Application Ref:	3/2026/0119			 Ribble Valley Borough Council www.ribblevalley.gov.uk
Date Inspected:	N/A	Site Notice:	N/A	
Officer:	AR			
DELEGATED ITEM FILE REPORT:				APPROVAL

Development Description:	Certificate of Lawfulness for proposed alterations and extension of dwelling.
Site Address/Location:	The Bungalow Simonstone Lane Simonstone BB12 7NU

SHEET: PROPOSED ELEVATIONS 1

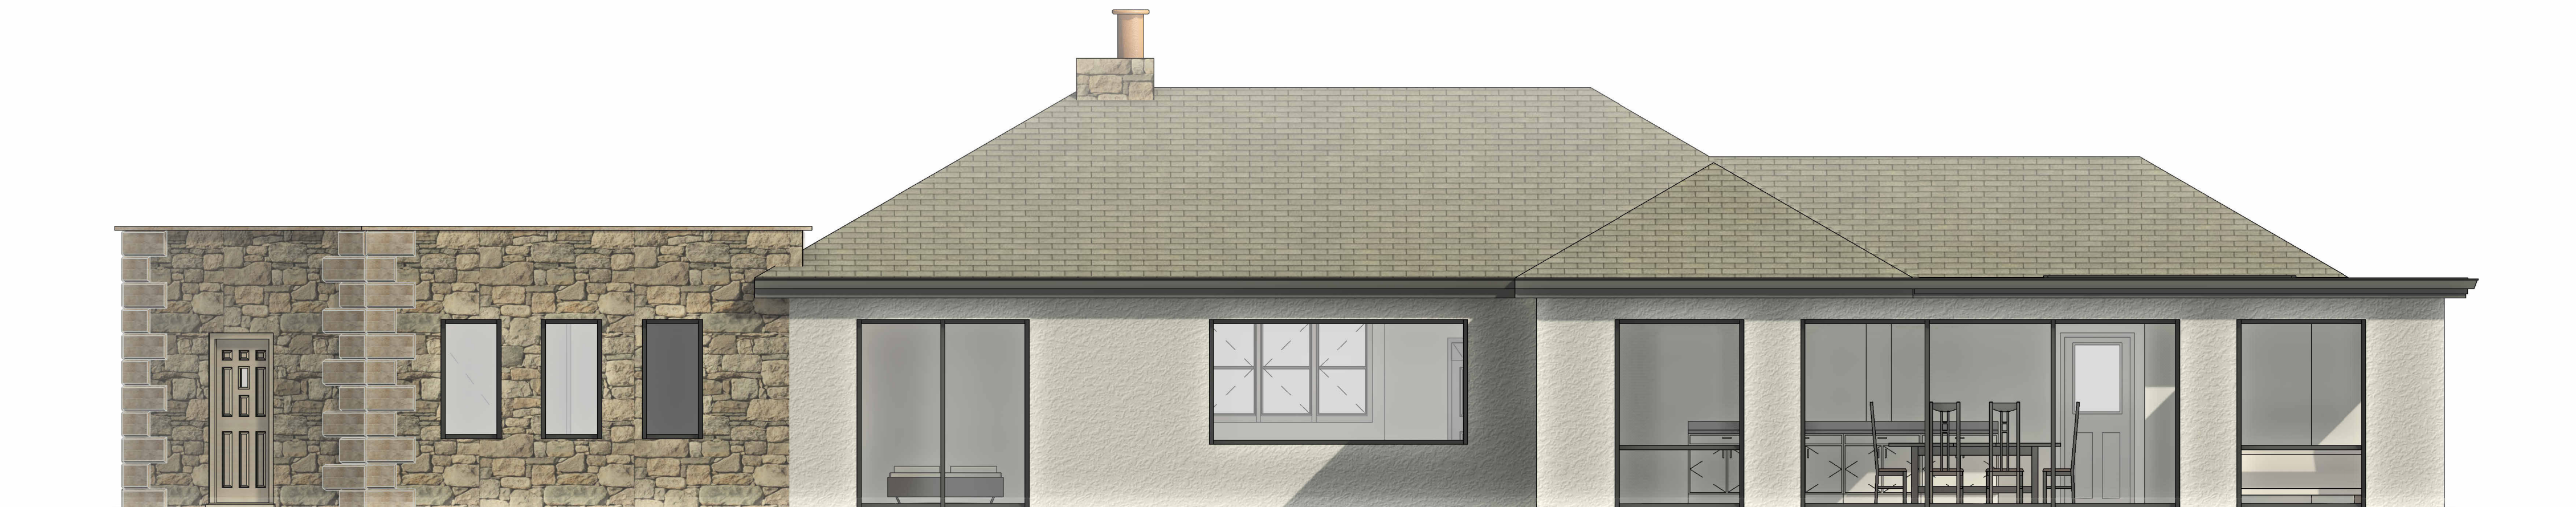
Consent is sought for a Certificate of Lawfulness for the construction of a single-storey side extension, projecting 1.5m from the rear of the existing garage side extension to align with the original rear wall, with an eaves and ridge height of 2.4m and 2.48m respectively. The existing side timber lean-to porch is to be removed and the existing garage reconfigured. To the east and south elevations of the original dwellinghouse, three sets of sliding patio doors would be featured.

A side extension is also proposed on the eastern elevation which would protrude out by 1.3m and would have a width of 4.2m to allow for a sheltered canopy area. The proposal would feature a flat-roof design with a maximum height of 2.66m to match the eaves of the existing dwelling house.

The planning officer has asked for amendments to the application to remove the proposed porch on the principal elevation, reduce the width of the side extension and reduce the extension ridge height to 2.48m to align with the provisions of Schedule 2, Part 1, Class A, B and C of the Town and Country Planning (General Permitted Development) Order 2015 (as amended).

The enlarged part(s) of the dwellinghouse would extend beyond a wall forming a side elevation of the original dwellinghouse, however it would not exceed 4m in height, have more than a single storey or have a width greater than half the width of the original dwellinghouse.

SHEET: PROPOSED FLOOR AND
EAVES PLAN

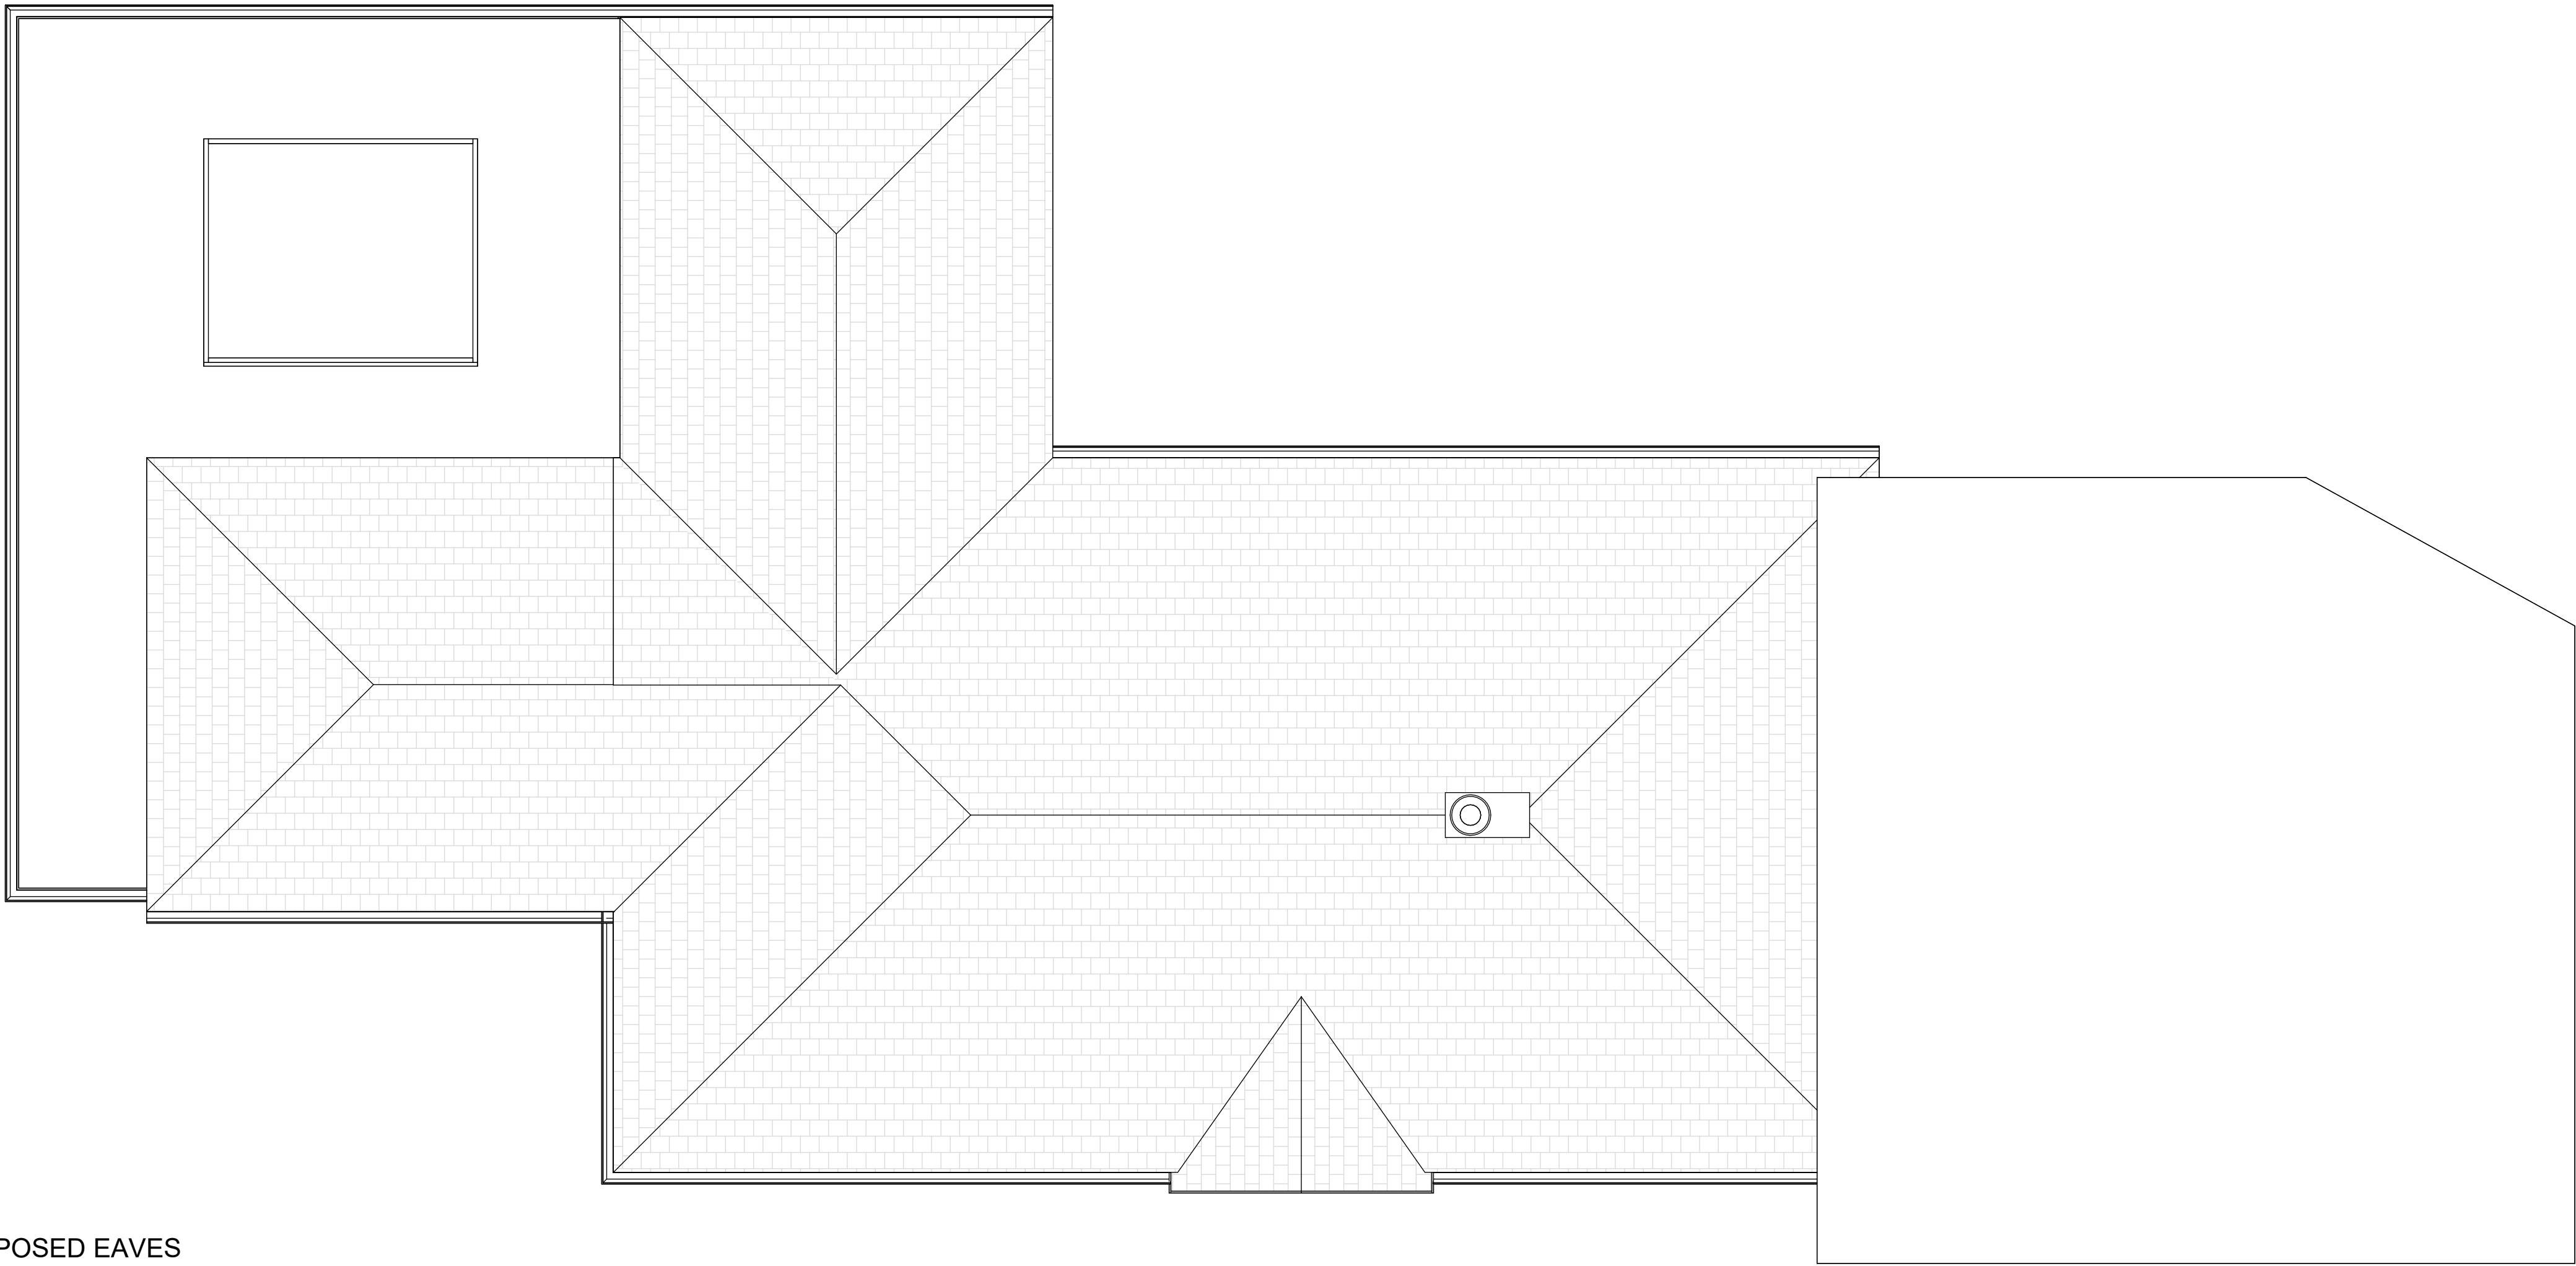
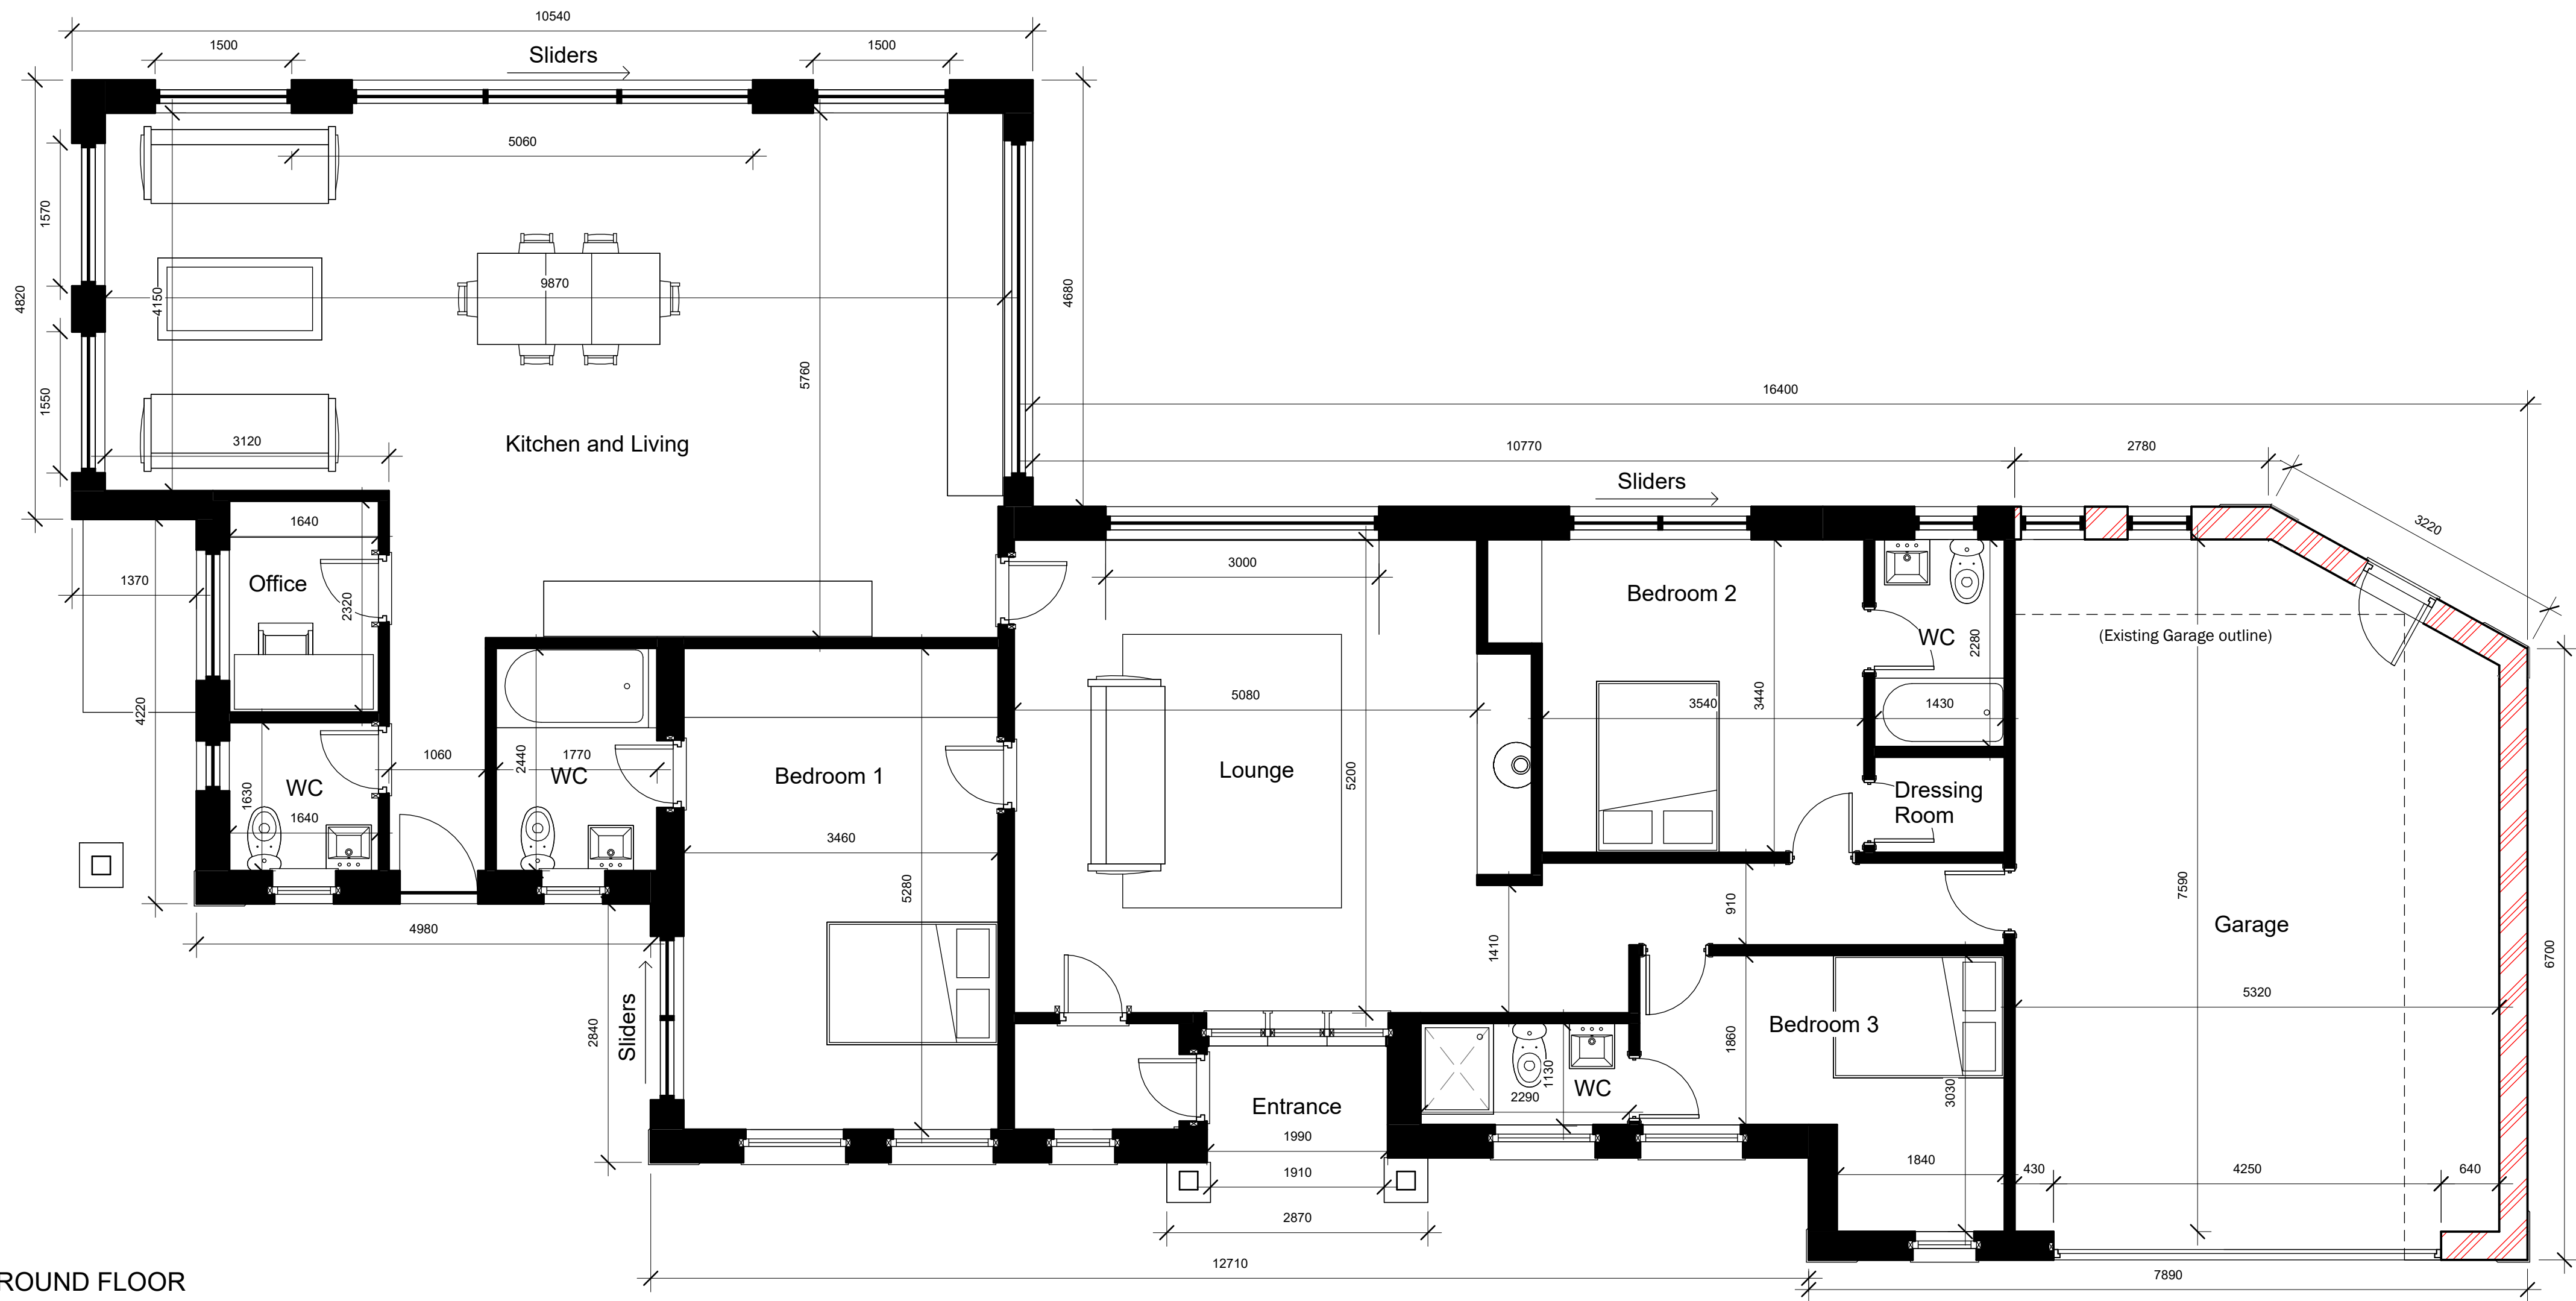
As part of the overall proposal, several new windows would also be installed on the east and south elevations of the main dwellinghouse, as well as a rooflight on the flat roof of the kitchen/living room.
